Our Case Number: ABP-314724-22

Re: Railway (Metrolink - Estuary to Charlemont via Dublin Airport) Order [2022]
Metrolink. Estuary through Swords, Dublin Airport, Ballymun, Glasnevin and City Centre to
Charlemont, Co. Dublin

Re: Railway (Metrolink-Estuary to Charlemont via Dublin Airport) Order {2022}

Drawing file: No.12 - TII (Applicant) / 3b. Airport Tunnel Drawing_2_ML1-JAI-ARD-ROUT_XX-DR-Y-03036.pdf

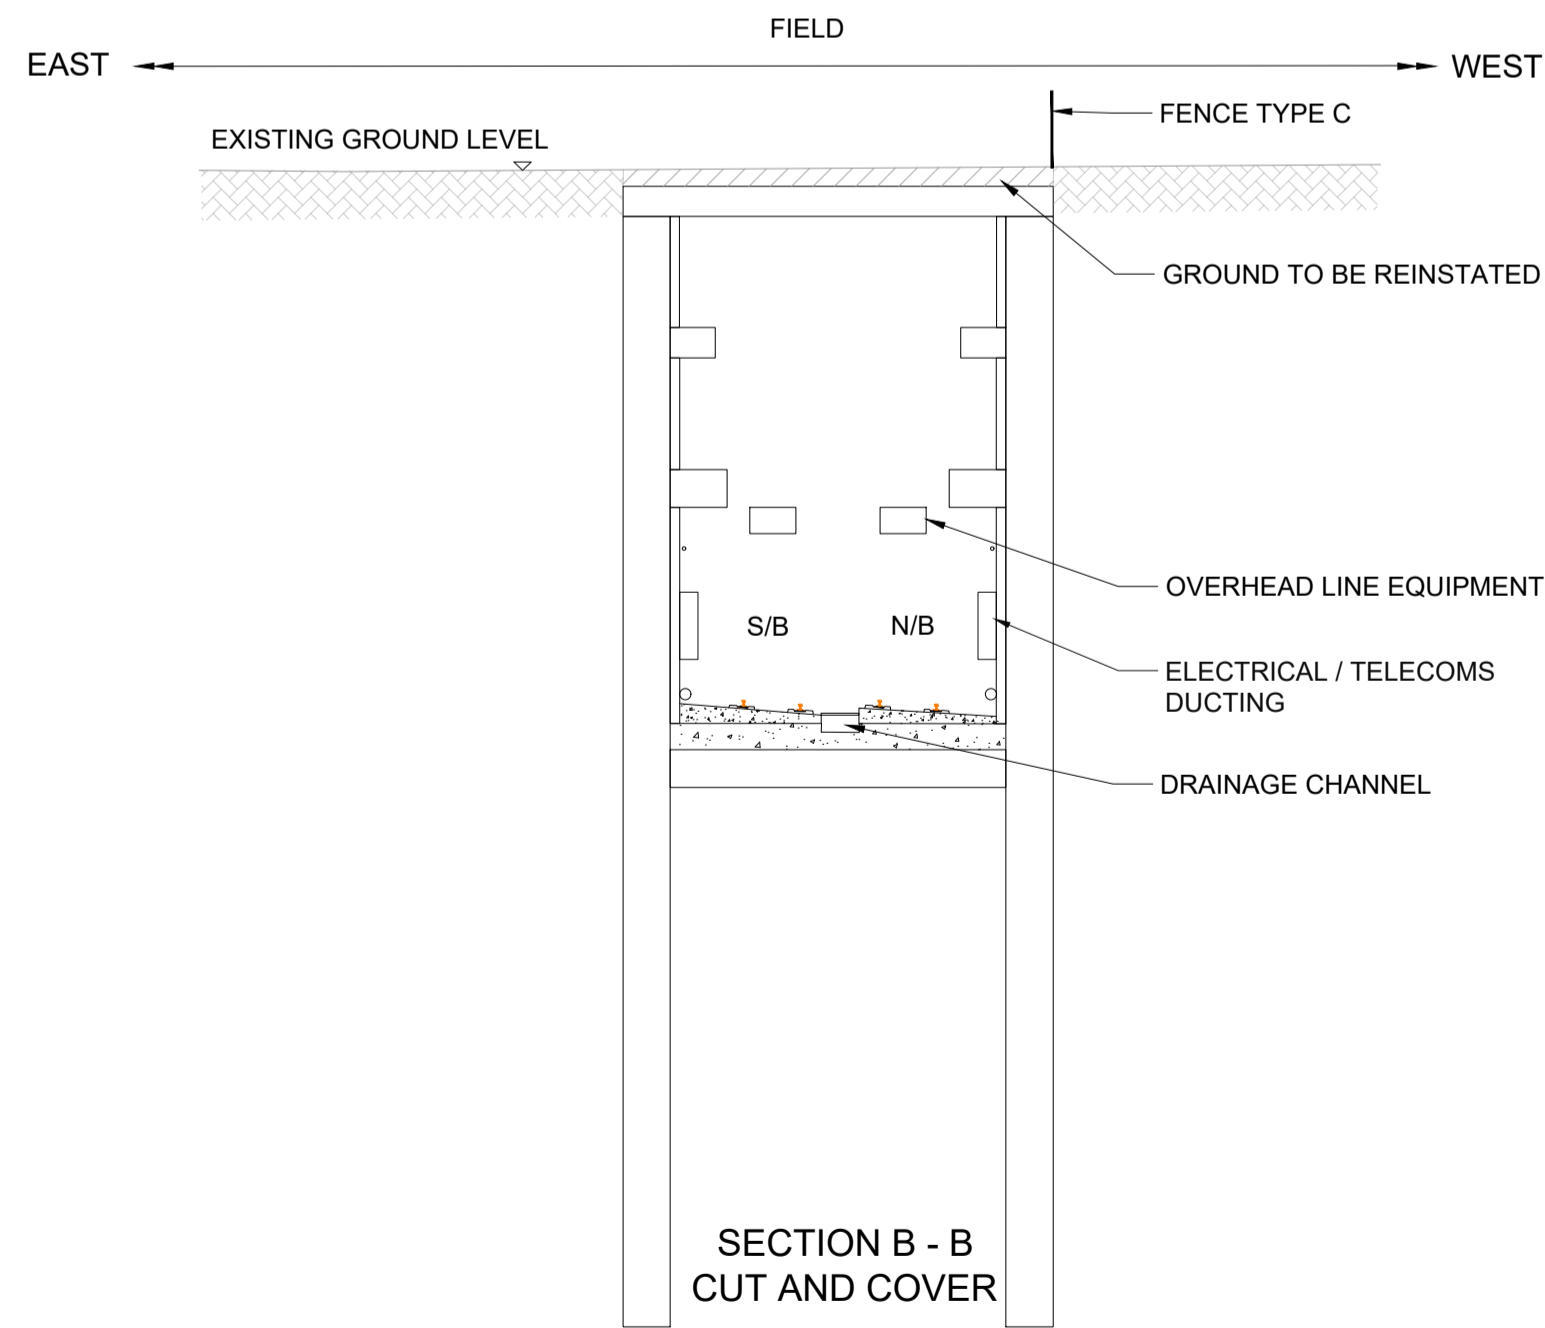
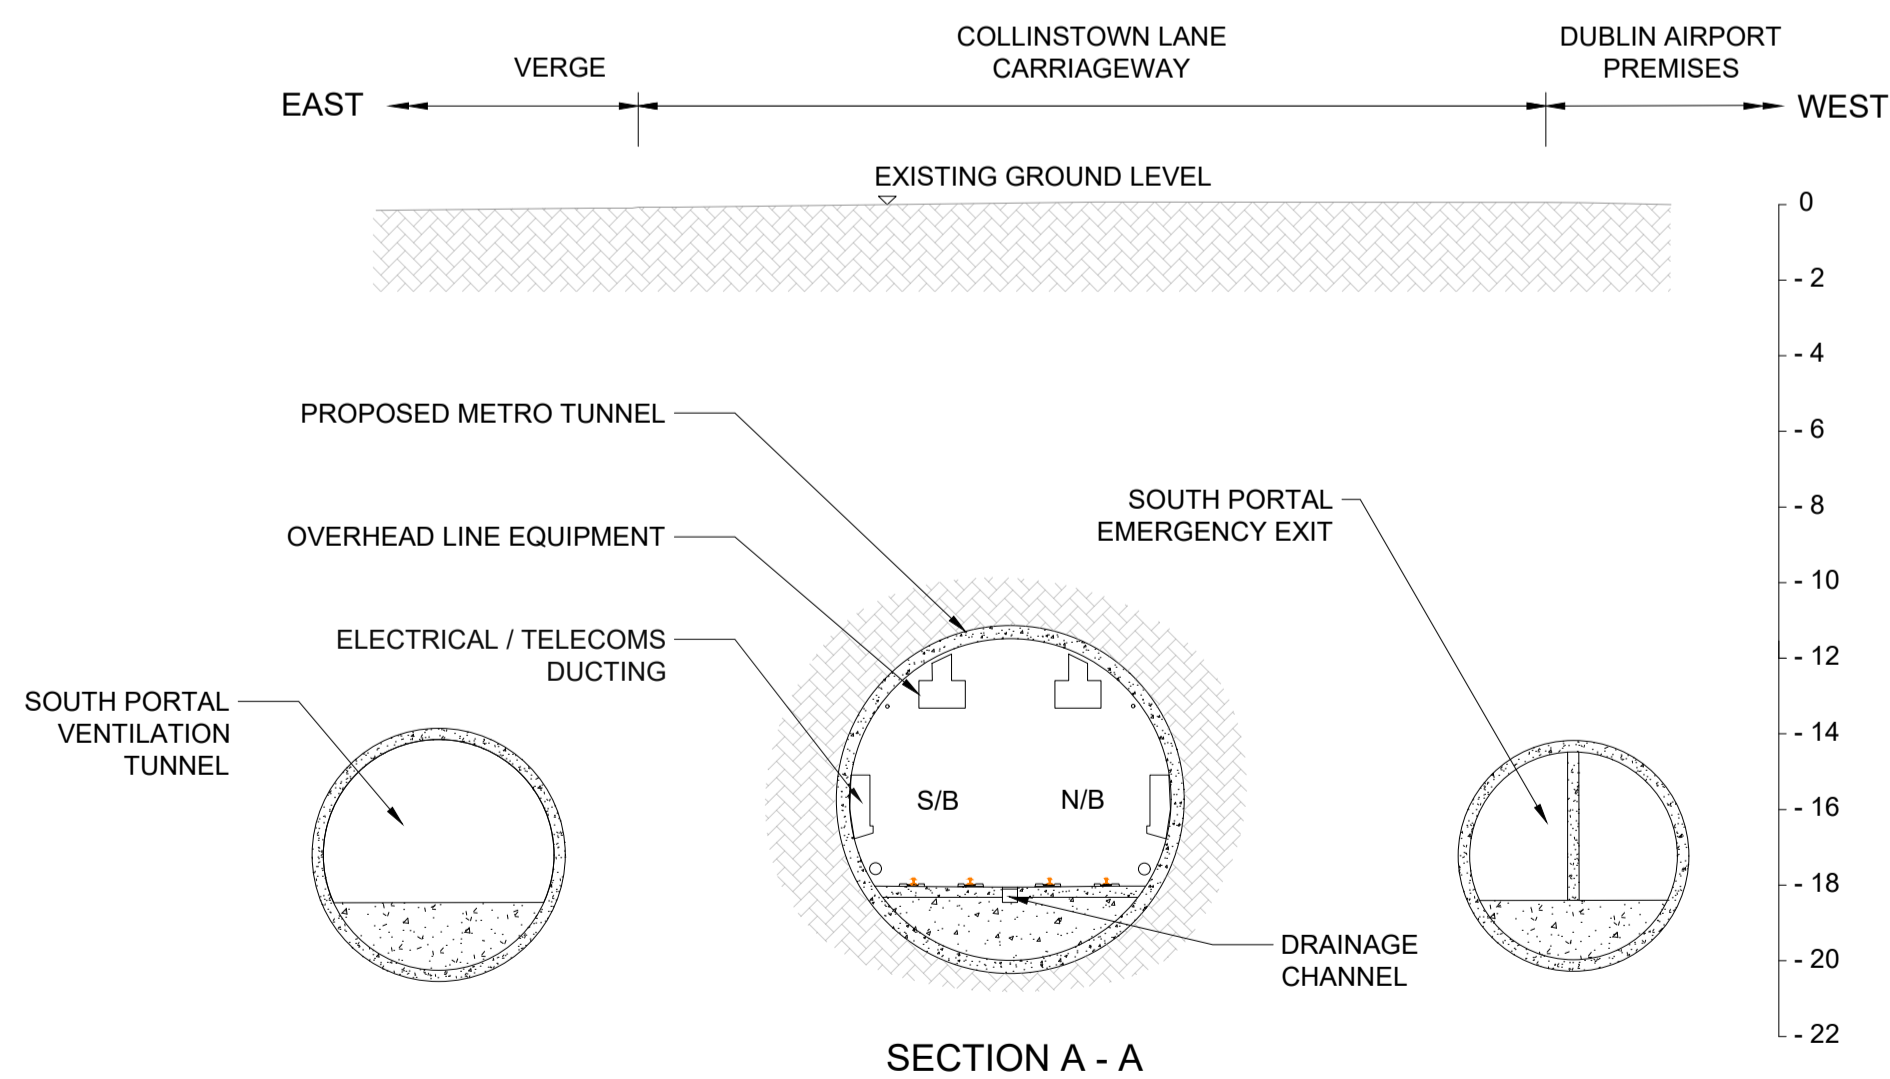
On 1st inst I met with a DAA representative and outlined how the proposed shallow tunnel depth as section AA at ML RO 302 D-E could jeopardise the construction of a possible APM (Automatic People Mover) above the metro tunnel.

Were TII to delay the incline SB from the Dublin Airport station to the additional Airport Tunnel drawings (submitted by TII on Day 6 Book 1 of 1) would give DAA greater flexibility and depth {centrally located airside between T1 & T2} to construct a screened passenger APM link at Level -1 to DAA's indicative Western Satellite Pier.
